Recommendation Report for Planning Permission for Works or Extension to a Dwelling

REF NO: AW/383/21/HH

LOCATION: 22 Gossamer Lane
Aldwick
PO21 3BY

PROPOSAL: Retrospective application for erection of outbuildings in rear following demolition of existing.

Proposed Front South West Elevation

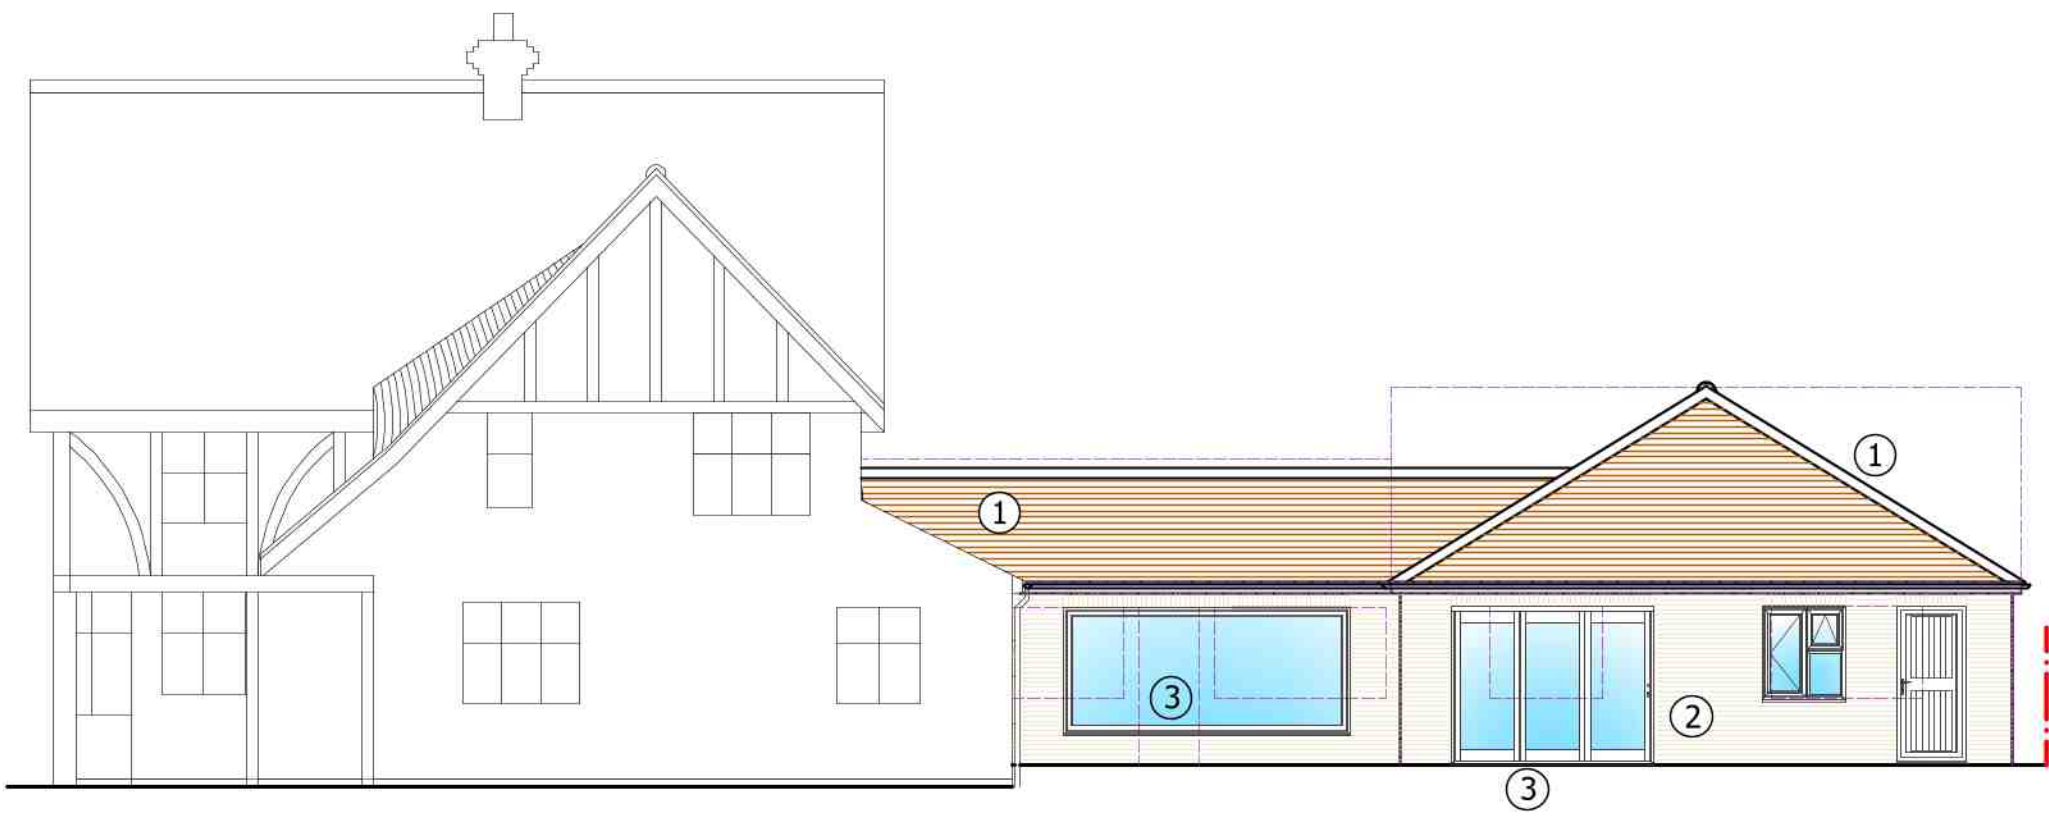
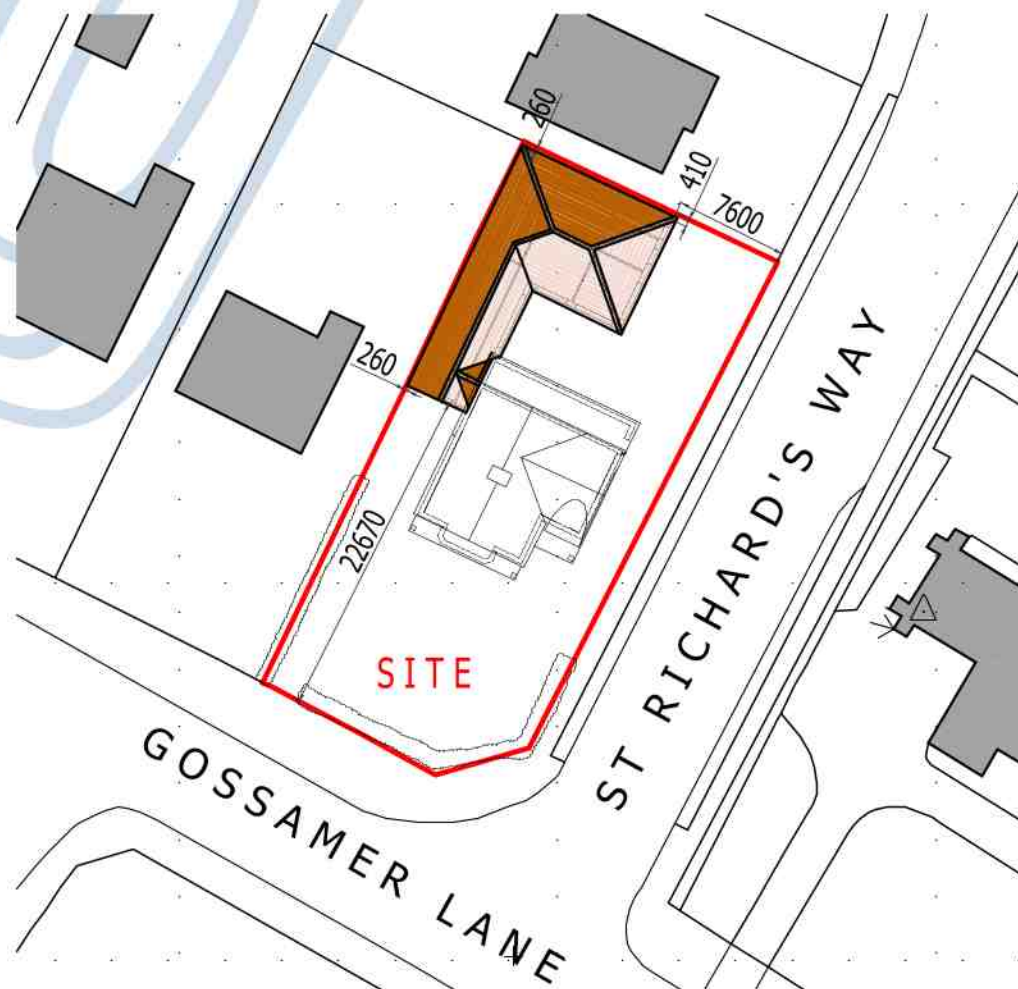
The development forms a pitched roof garage which fronts the road and extends along the western boundary forming an outbuilding with a height of 4.05m along the boundary with eaves to 2.6m. This increases to a maximum of 5.1m to the ridge of the hip, which at its highest point, sits around 4m from the western boundary. This extends above the fence line and will be highly visible, providing some overbearing upon the occupiers at No.24.

This however does not increase in height when compared to the structure that it has replaced. Additionally, the roof serving the rear element of the outbuilding has altered from a gable end to hip end and therefore the design reduces the visible dominance its has upon No.24 when compared to the previous outbuilding. As such with the development being largely replacement in nature, with the height remaining the same as that which previously existed and with it sloping away from the boundary, it is not considered to result in adverse overbearing or overshadowing upon the neighbouring property at No.24.

Proposed Site & Ground Floor Plan

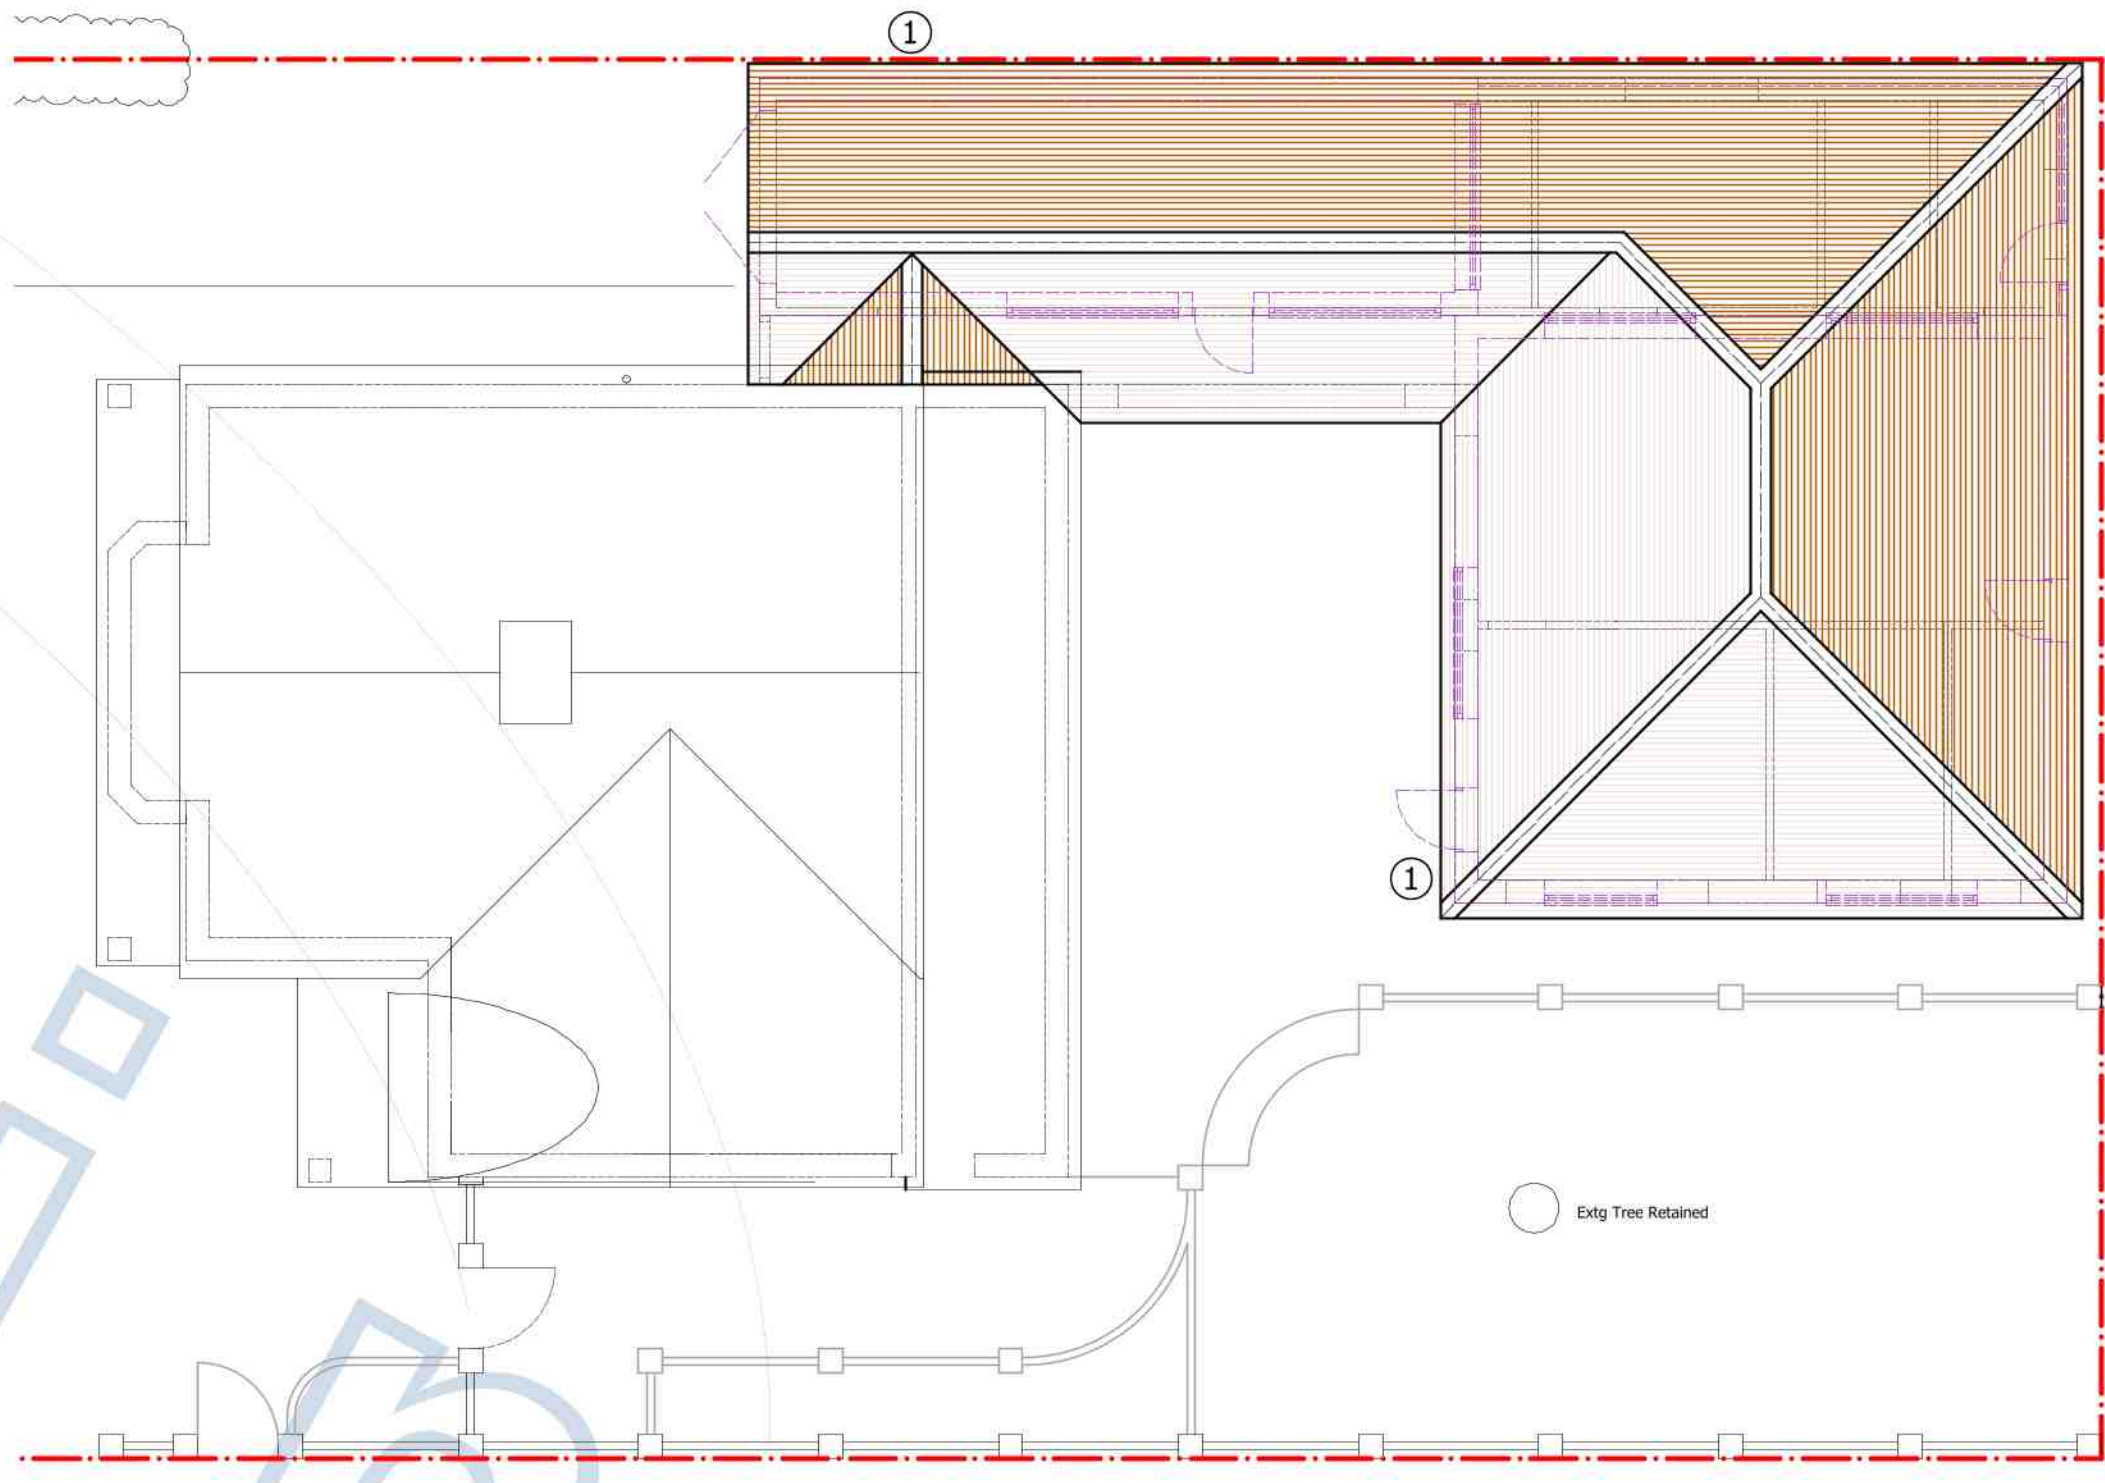
The addition will form a pitched roof garage to the south western side of the dwelling and extend along the western boundary forming a hipped roof outbuilding. This is largely the same footprint as existing although the garage will increase in width 1.15m to meet with the rear corner of the dwelling to form an access corridor to the main outbuilding.

To the rear elevation, the outbuilding extends along the northern boundary with a depth of 11m. There is a neighbouring property to the north and the outbuilding runs along its full side elevation. There are two windows located to the ground floor which are impacted by the outbuilding although with the height and footprint remaining as existing the harm created has not increased and is not considered significant.
